From: Hornby, Mark [Mark.Hornby@lancashire.gov.uk]
Sent: 01 October 2012 16:24
To: Graeme Thorpe
Cc: ENV EPP Customer Service Area East
Subject: Planning Application 03/2012/0401 - 51&53 Knowsley Road, Wilpshire
Graeme

Further to our site meeting with the developer and their agent on 2nd February 2012 and subsequent discussions I have the following comments on this outline application:

Drawing Title
Proposed Ground Layout

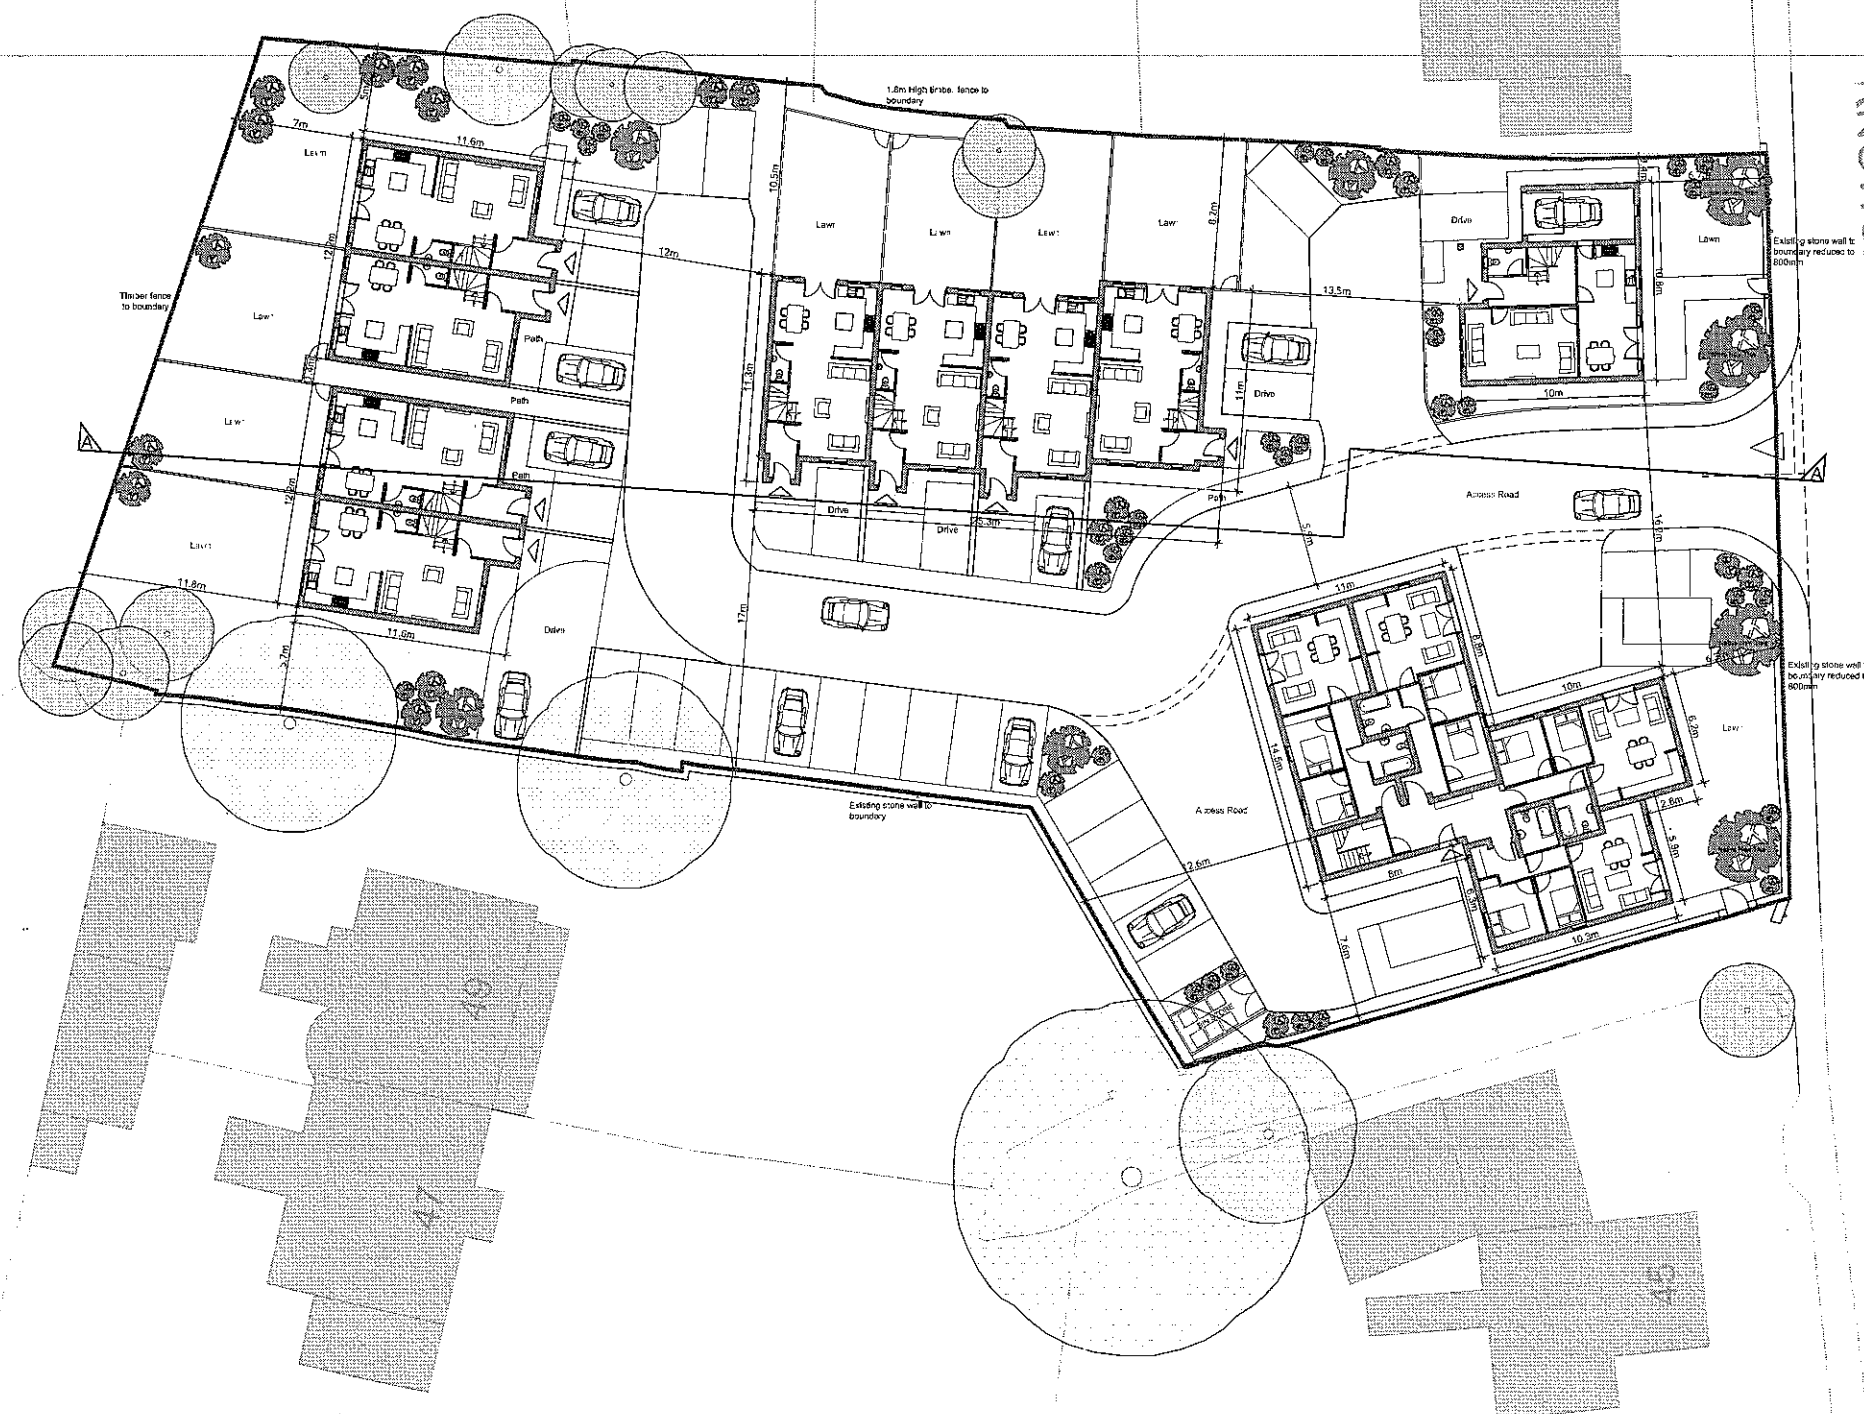
- Adequate visibility splays of 2.4m x 50m are achievable in both directions along Knowsley Road, albeit with the reduction of the boundary wall to a maximum height of 0.8m.
- The levels of parking proposed within the site are appropriate to the mix of properties proposed, with 3 spaces for the 4 bed house, 2 spaces for each 3 bed house and 1 space per flat making a total of 31 off-street spaces. This is consistent with our policy on parking provision.
- The internal access road is 5.5m wide and has sufficient manouvering space to allow refuse vehicles etc. to turn within the site.
- The kerb radii at the access to Knowsley Road were too tight as shown on the original plans. I contacted the architects SPA to see if they could be eased to provide a 6m radius and this has now been incorporated in Drawing No. 4186 - 07 Revision B.
